Recommendation Report for Planning Permission for Works or Extension to a Dwelling

REF NO: EP/51/26/HH

LOCATION: Dene Cottage
156 Sea Road
East Preston
BN16 1PB

PROPOSAL: Proposed single storey front extension / porch and new pitched roof over existing garage.

18 Parklands Avenue
Goring-By-Sea
West Sussex BN12 4NH

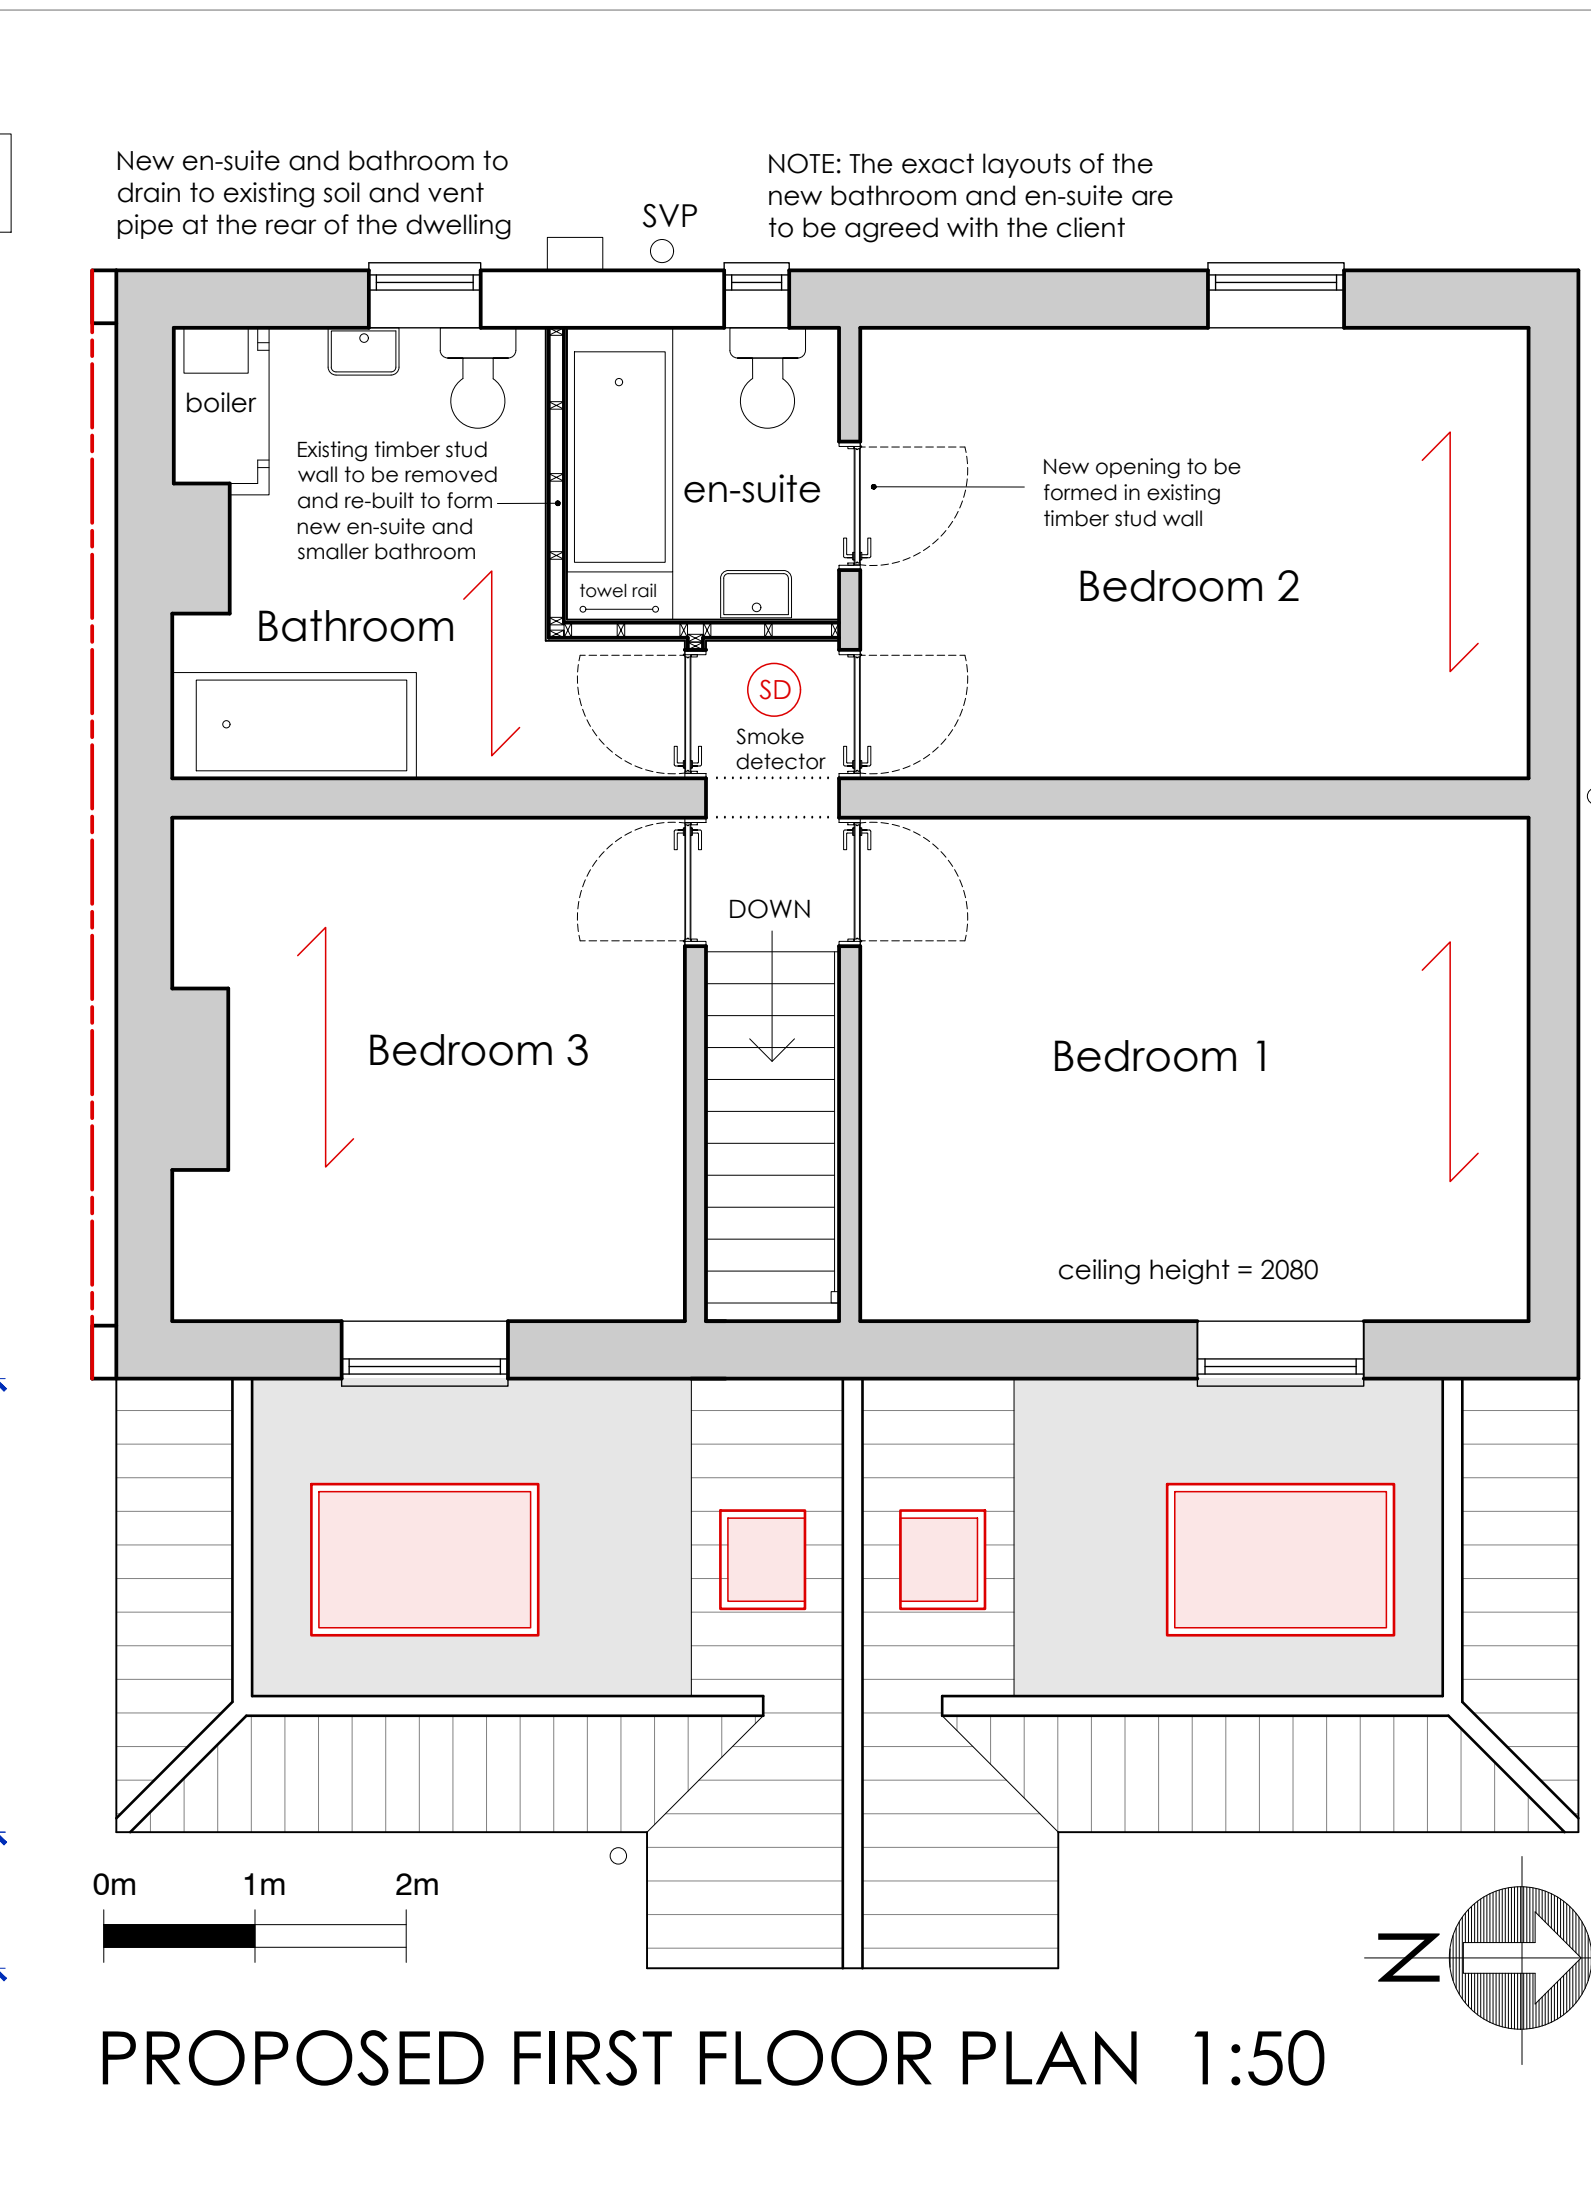
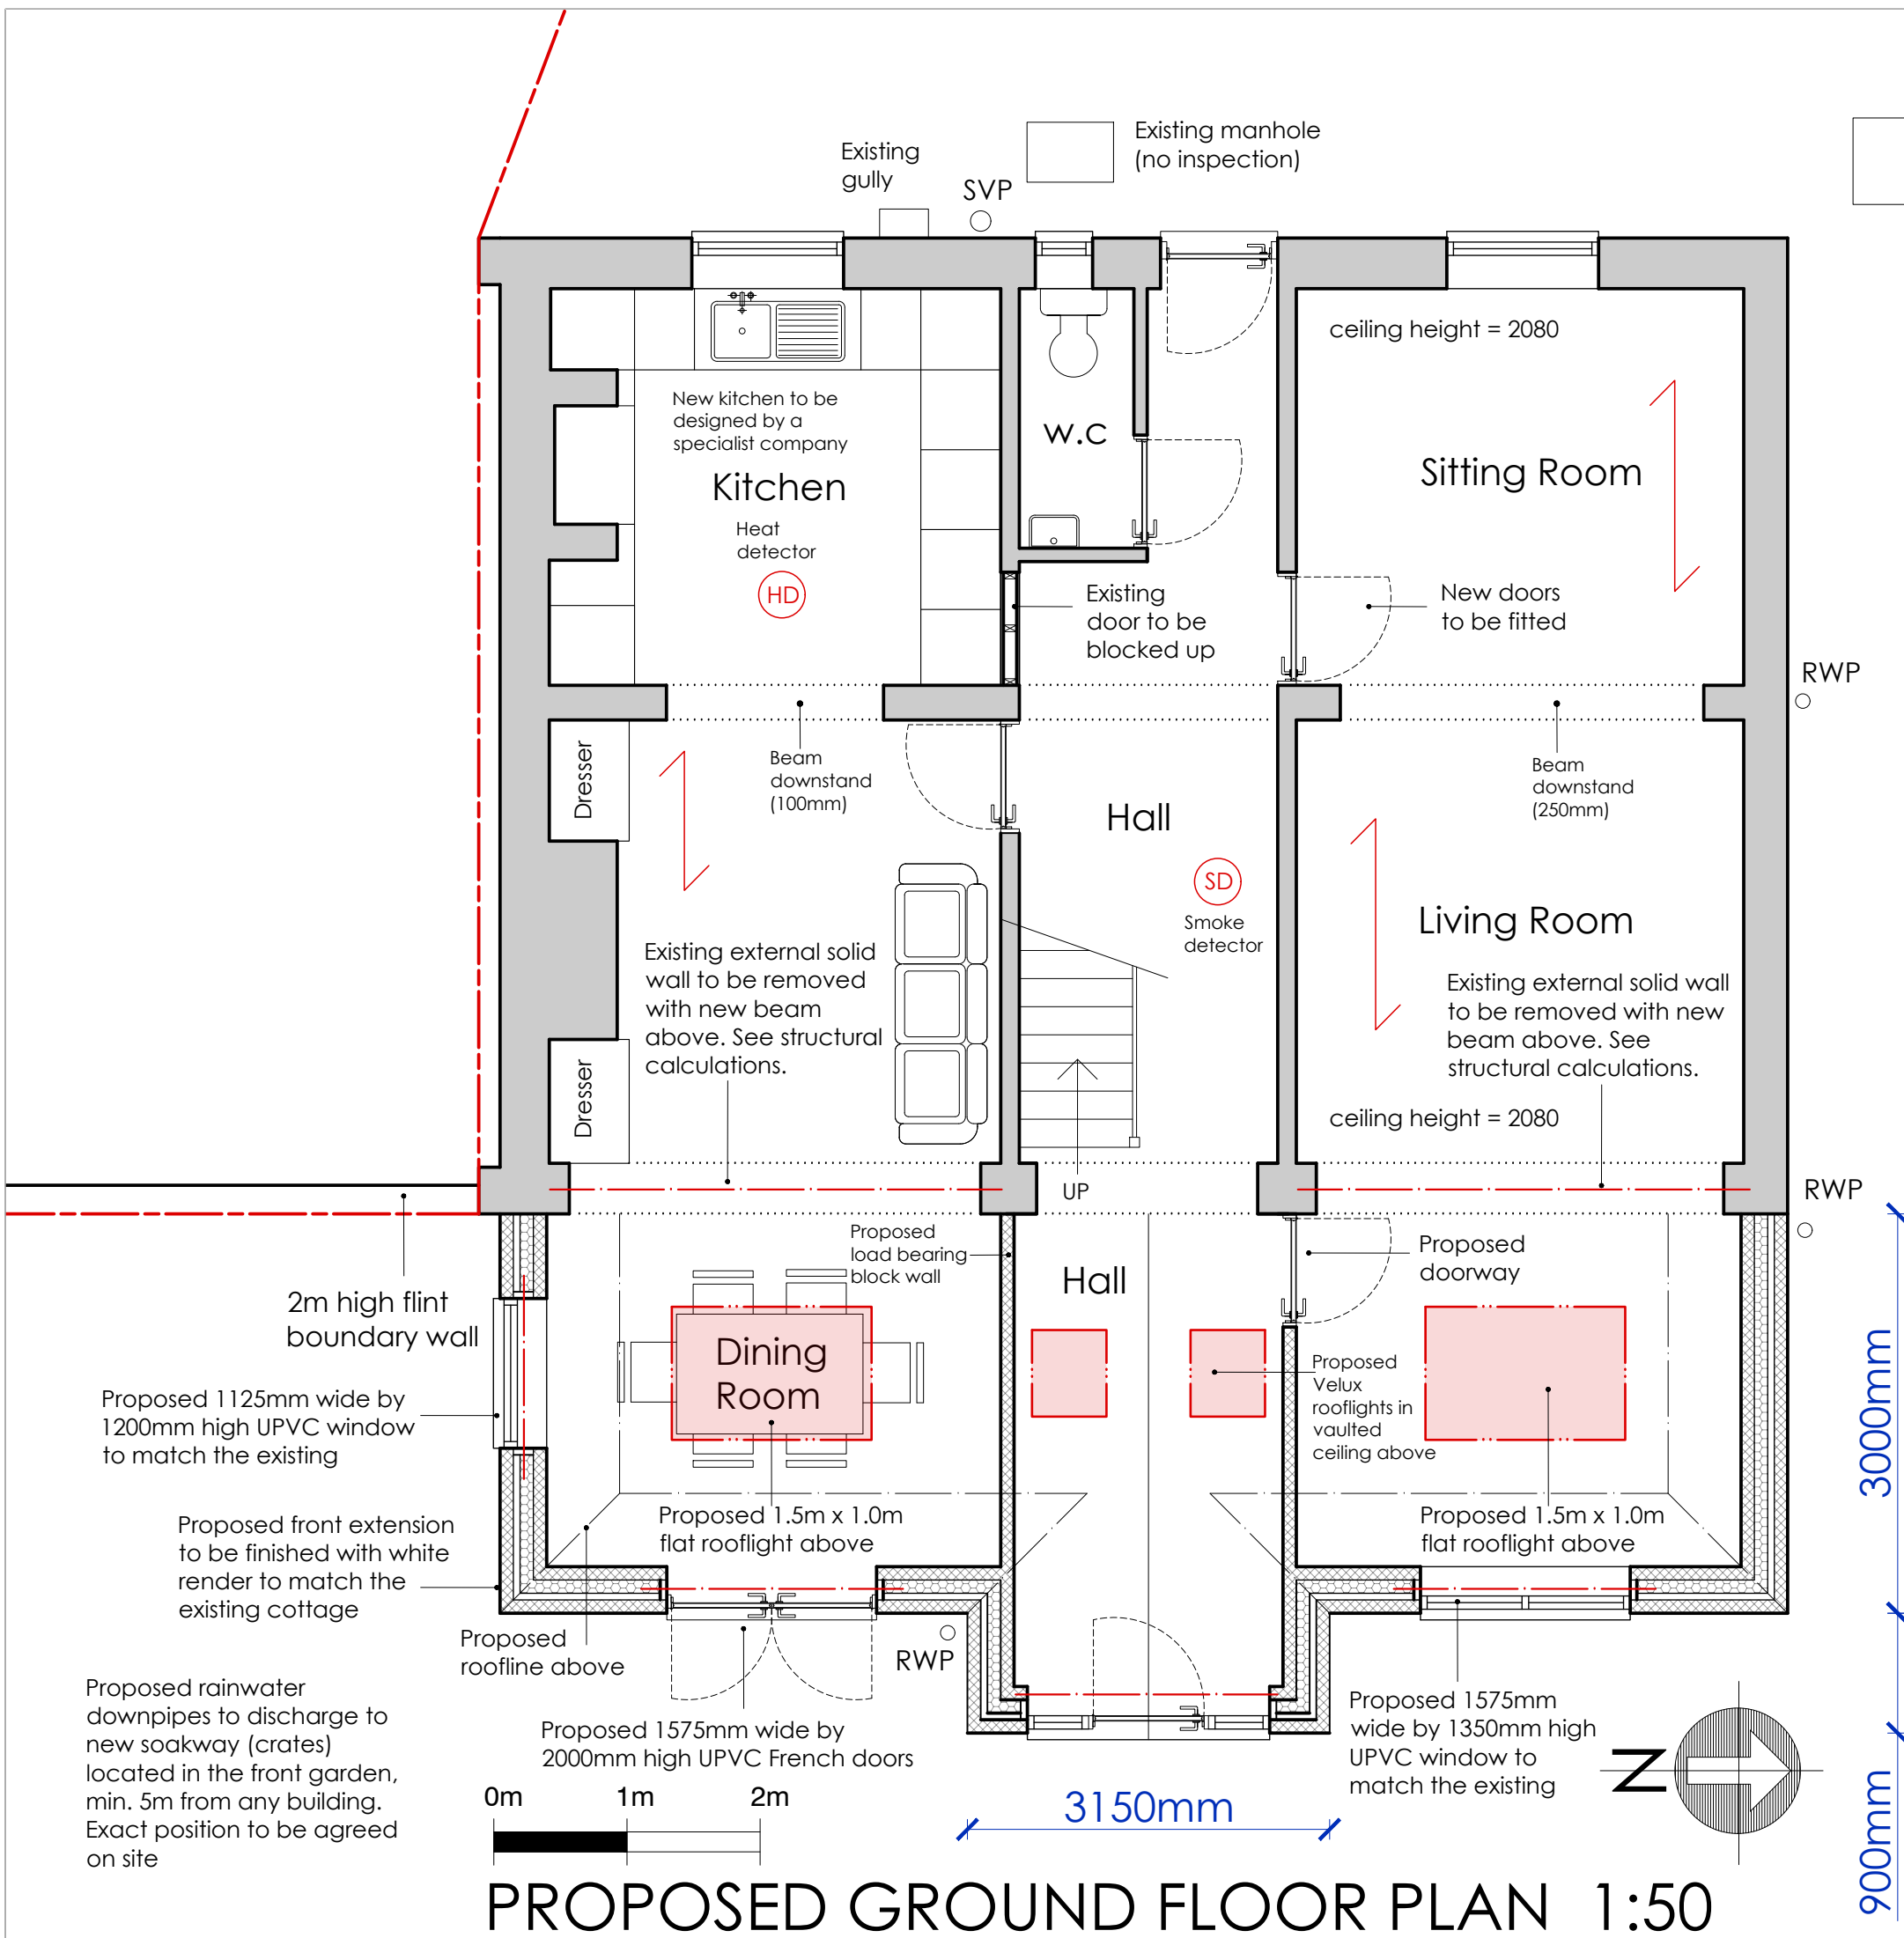
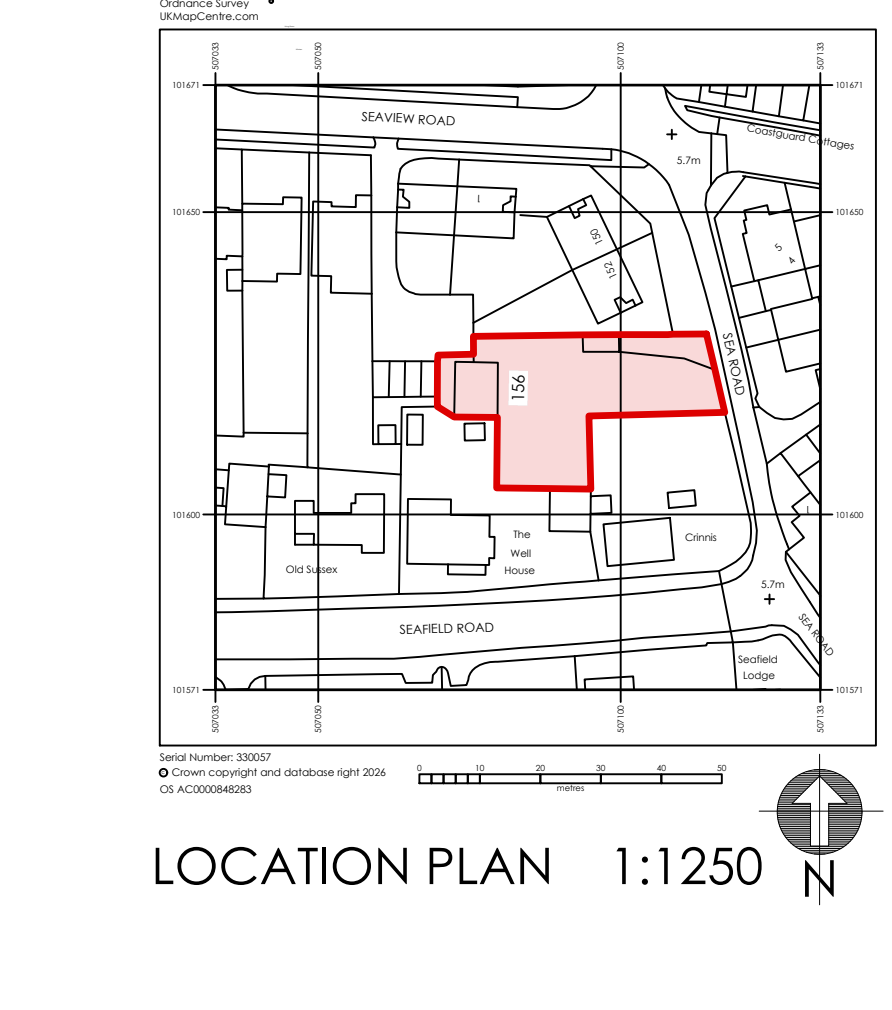
The extension would span the width of the host dwelling (10m) and would include a single storey projection (porch) with a pitched roof at a height of 3.7m, set in the centre of the extension with a depth of 3.8m (0.8m further than the remainder of the front extension). The remainder of the extension would have a crown roof, at a height of 3m, incorporating roof lights on each of the flat roofs either side of the central projection. Two roof lights would also be incorporated in the pitched roof slopes of the central projection.

The Arun Design Guide (ADG) states front / porch extensions should not exceed 1.5m in depth or be the full width of the dwelling. The proposal conflicts with these principles, however, given the size of the front amenity area, resultant distance from the highway (32m) and existing boundary treatment / screening, the proposal would not result in harm to visual amenity or the street scene.

The extension would be finished with white render, appropriate for the coastal setting and reflective of the existing render. Slate would be used on the roof slopes, to match the existing dwelling. The proposed material palette is appropriate and would ensure the extension would be congruous and subservient, in accordance with Arun Local Plan policies D DM1 and D DM4.

Owing to the proposed setting of the extension at the front of the dwelling and its single storey form, with fenestration proposed on the east (front) and south elevation only, any views available would be of the front and side gardens only, resulting in no harm by of overlooking.

While the extension does span the width of the dwelling, it would be set in by 3.8m from the northern boundary with the block of flats to the north (152 Sea Road). Considering this, as well as existing built form and boundary treatment, the proposal would not result in any overbearing or overshadowing impacts.

The extension would abut the site boundary with The Well House, to the south. Considering the existing boundary treatment (2m high flint wall), the outbuilding in the northeast corner of the garden at The Well House and its favourable siting to the south of the application site, there would be no harm by way of overbearing and overshadowing impacts.
